CONSTRUCTION PLANS
FOR
**CARRIAGE MEADOW SOUTH AT
LORSON RANCH FILING NO. 2**

**EARLY GRADING PLANS
AND DETAILED GRADING PLANS**

COVER SHEET
EARLY GRADING
AND EROSION CONTROL PLANS

DATE: FEB 12, 2020
PROJECT NO: 100.046
SHEET NUMBER: C0.1
TOTAL SHEETS: 14

SHEET INDEX	
SHEET NO.	SHEET DESCRIPTION
C0.1	COVER SHEET
C0.2	NOTES
C0.3	TYPICAL SECTIONS
C4.1 ~ C4.8	DETAILED GRADING PLANS (for information only)
C4.9 ~ C4.11	EARLY GRADING PLAN AND DETAILS

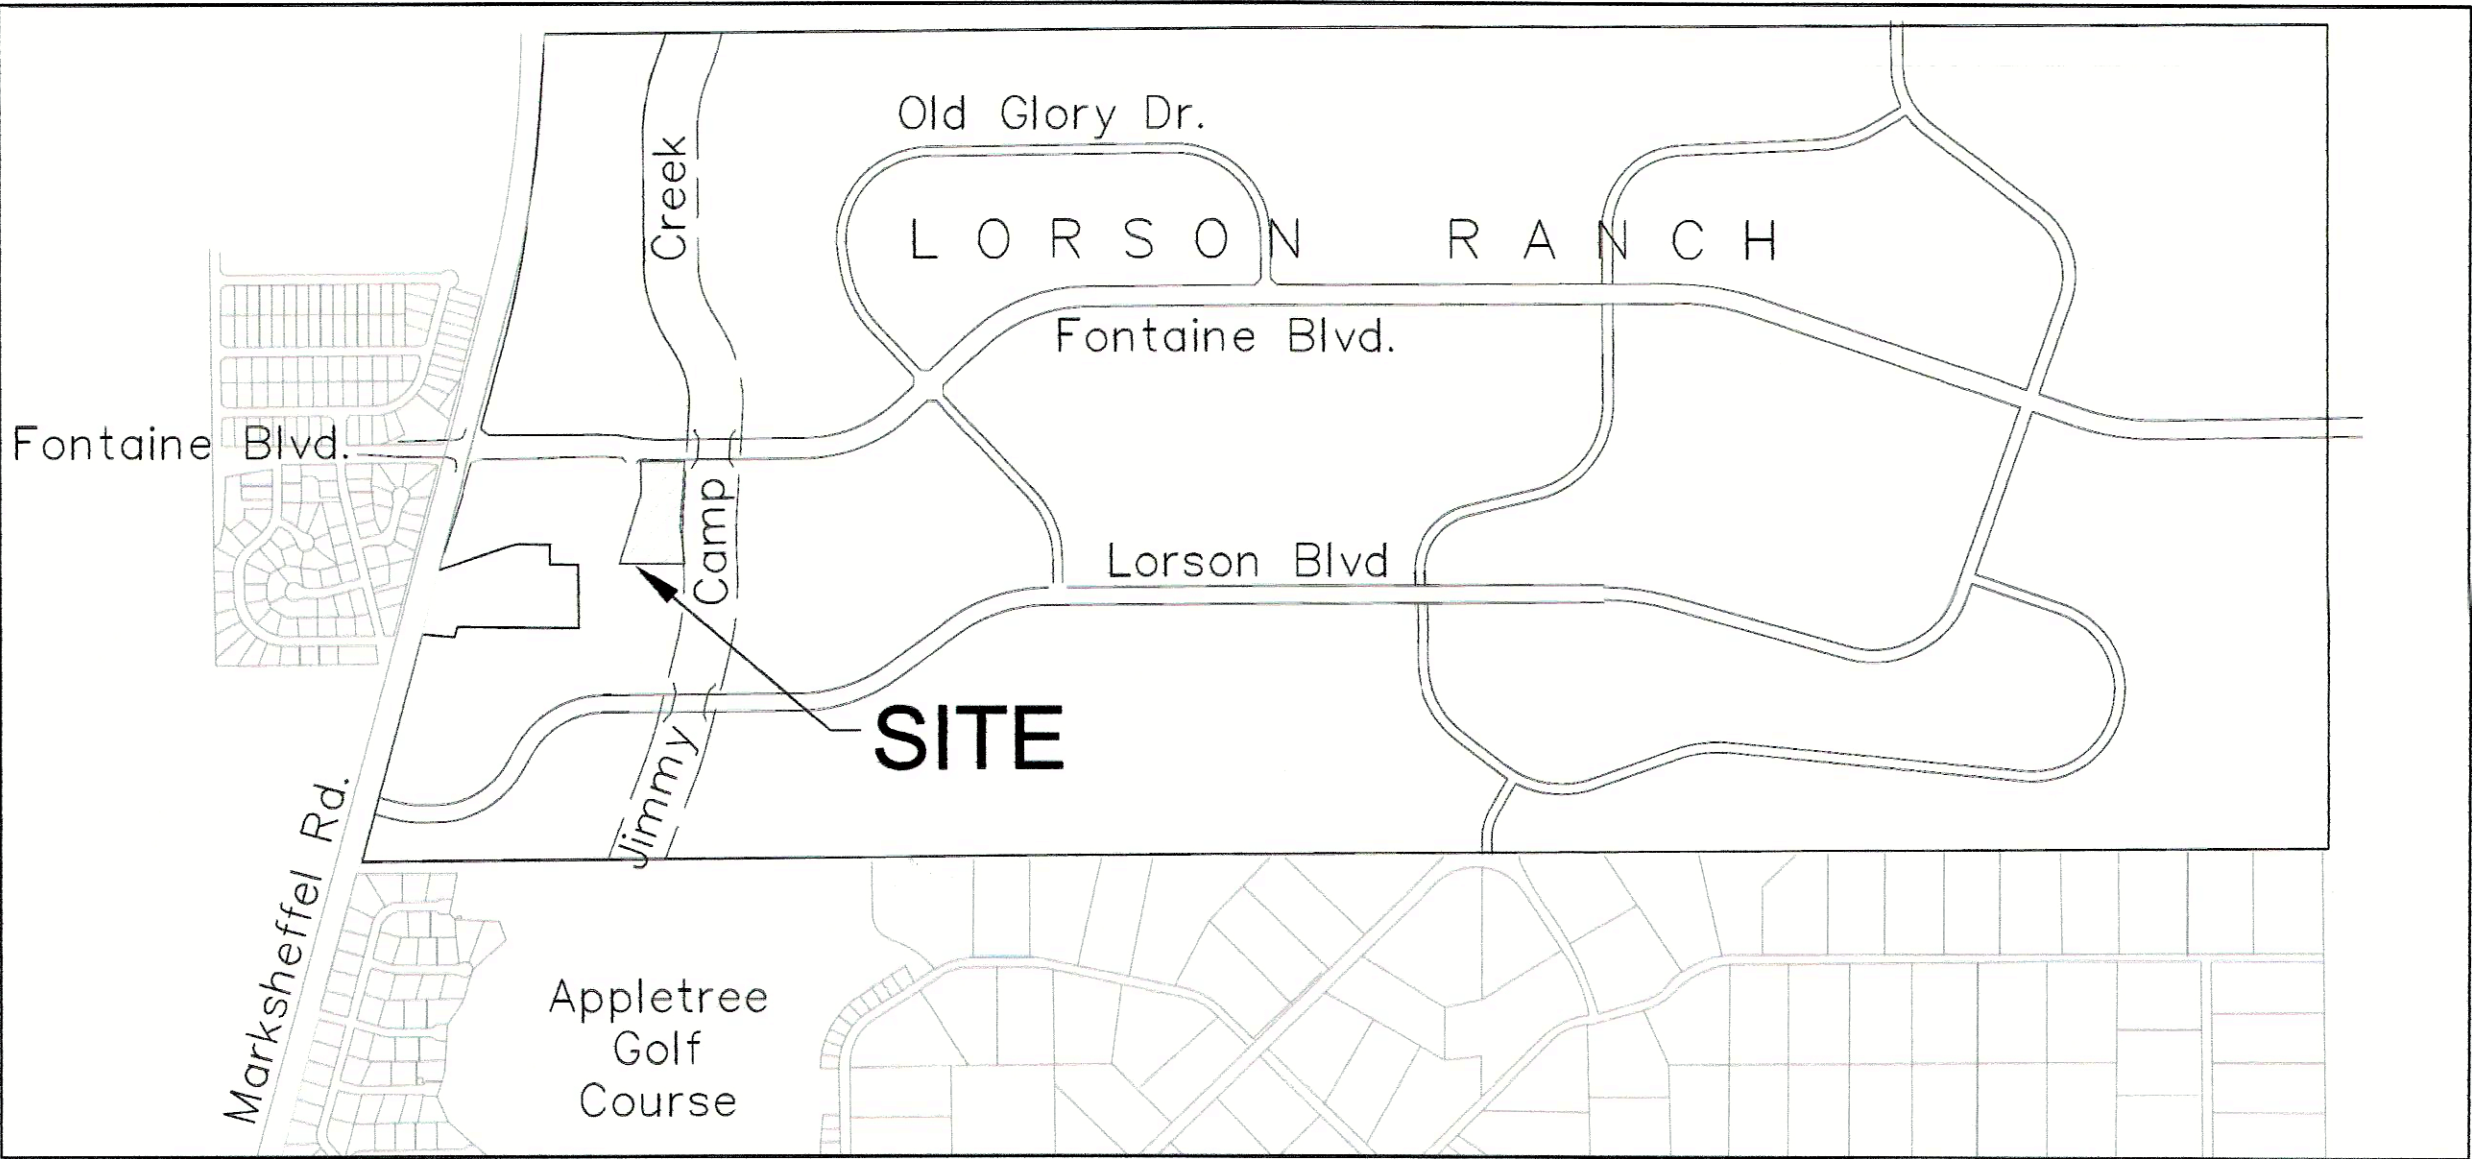
Change title, this is not
the Early Grading Plan

CARRIAGE MEADOWS SOUTH AT LORSON RANCH FIL. NO. 2 GRADING AND EROSION CONTROL PLAN

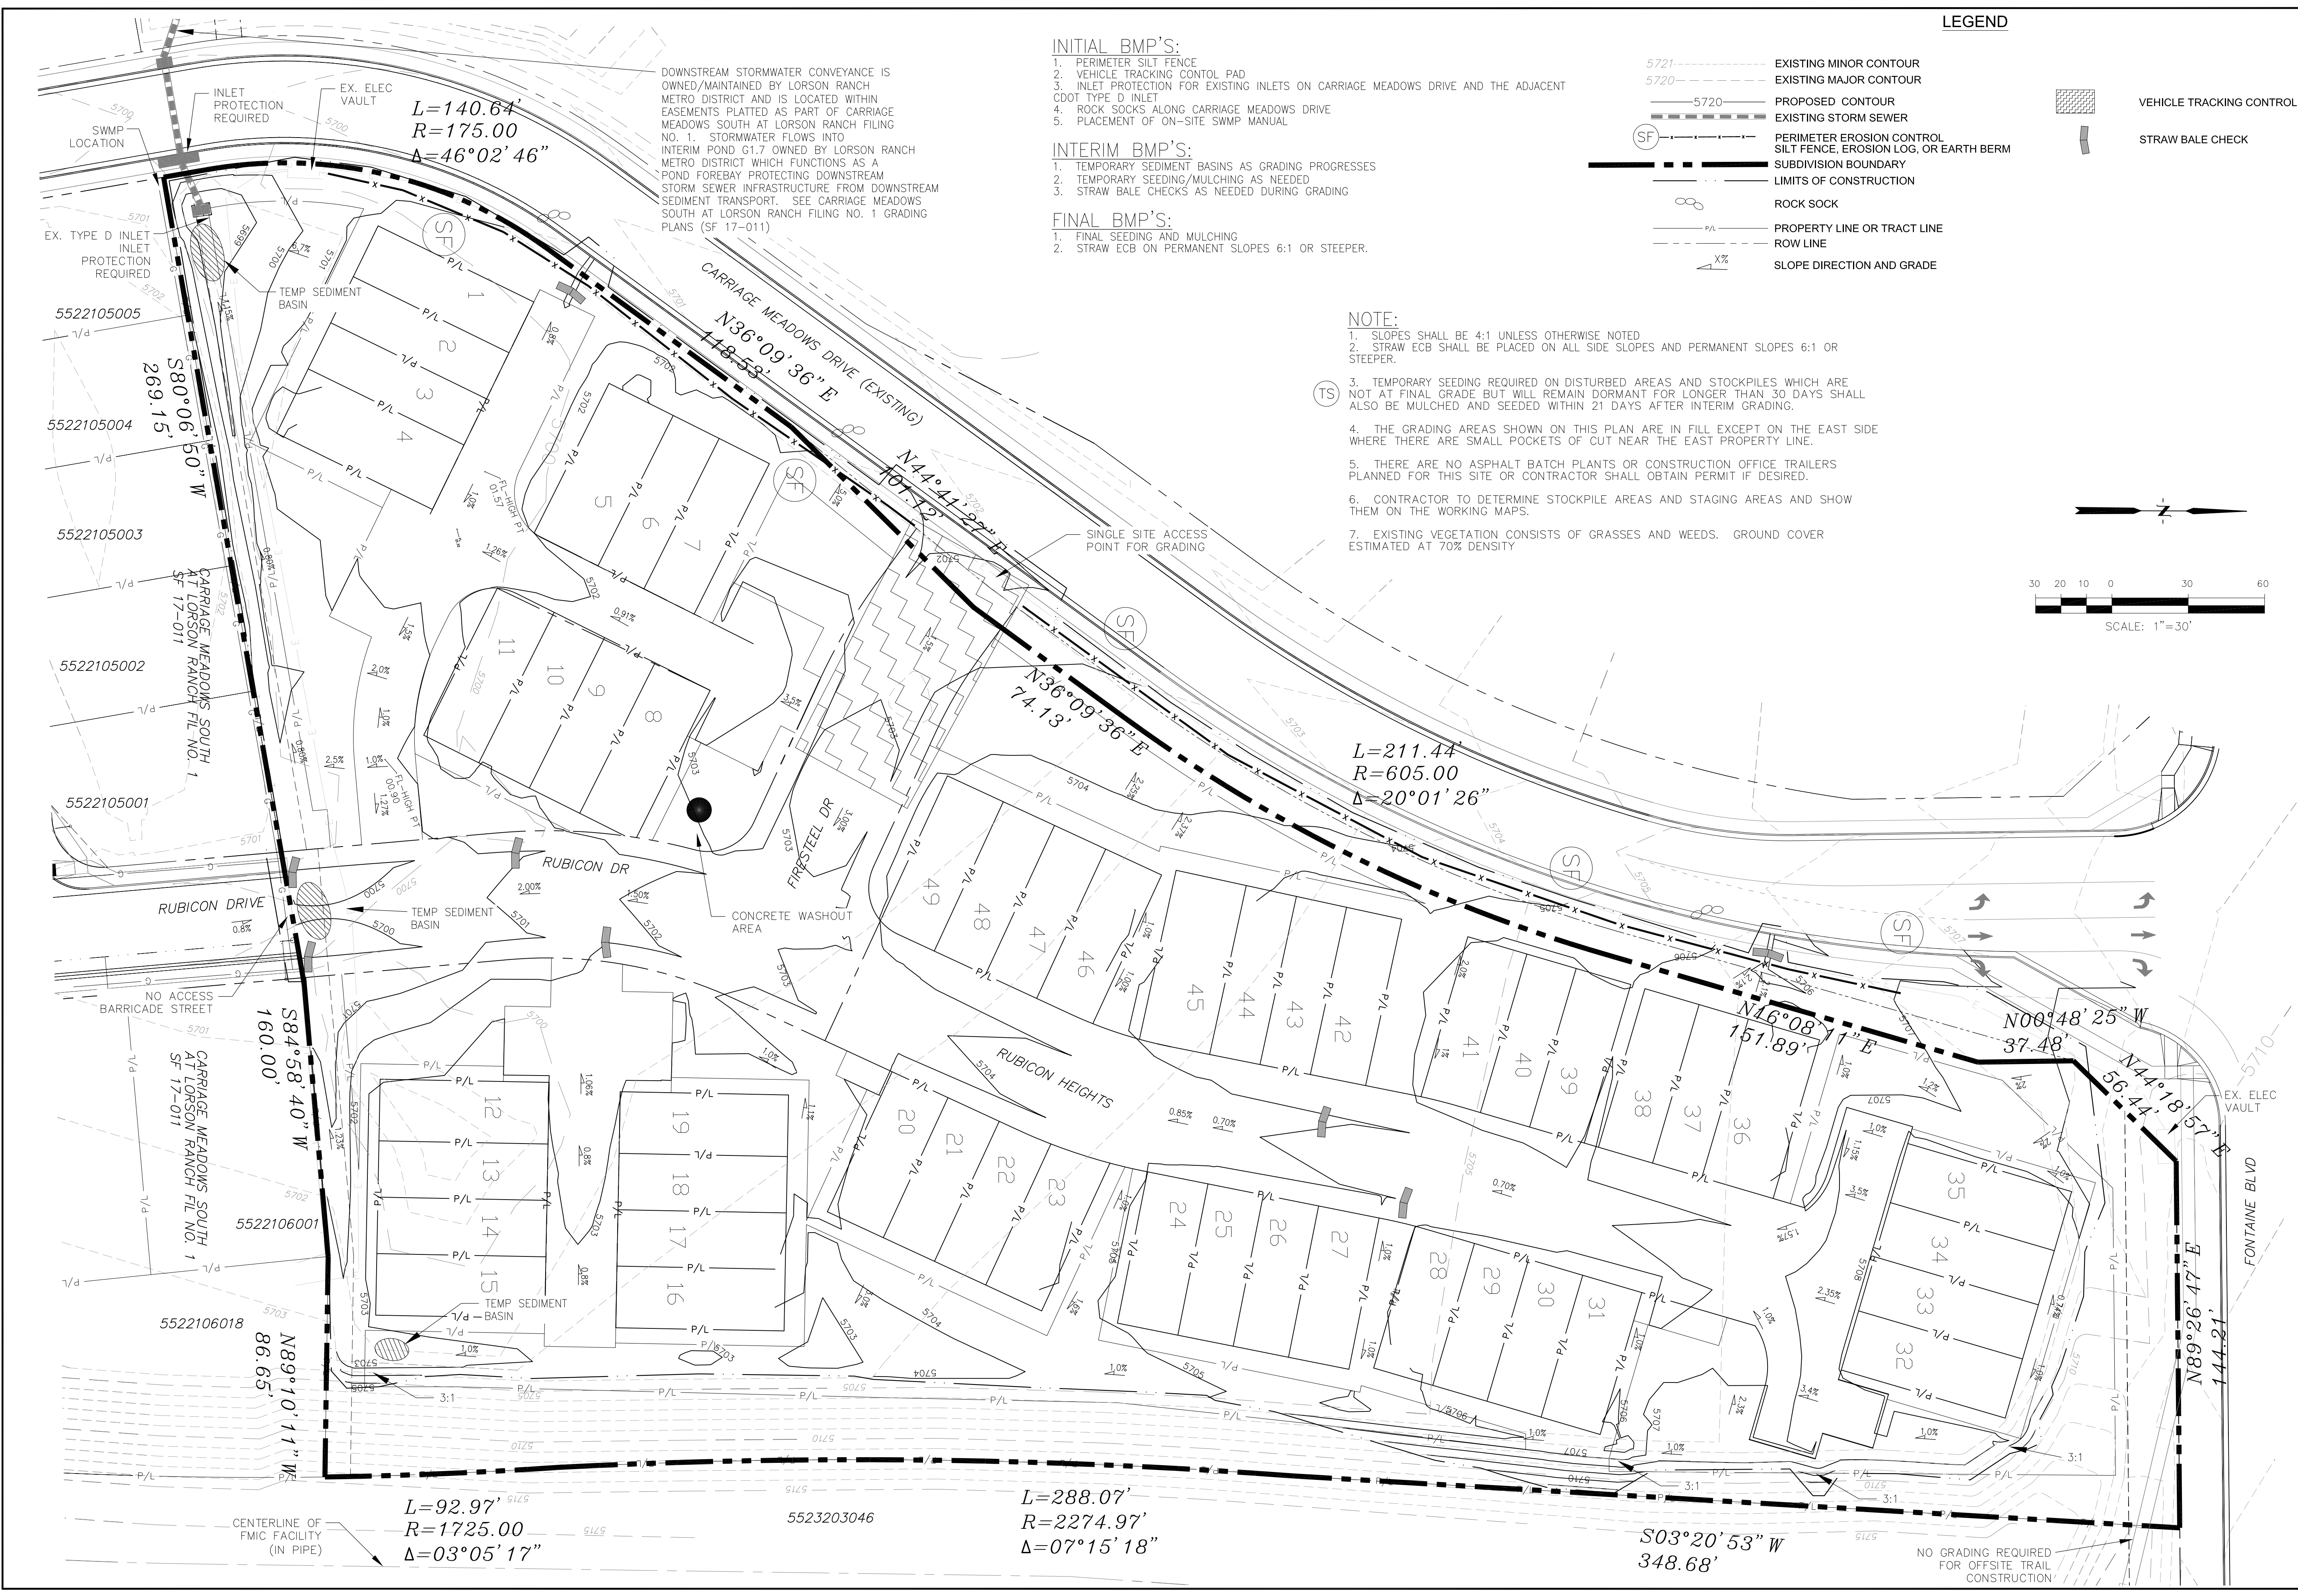
the existing contours should be updated to the current grades for this GEC plan
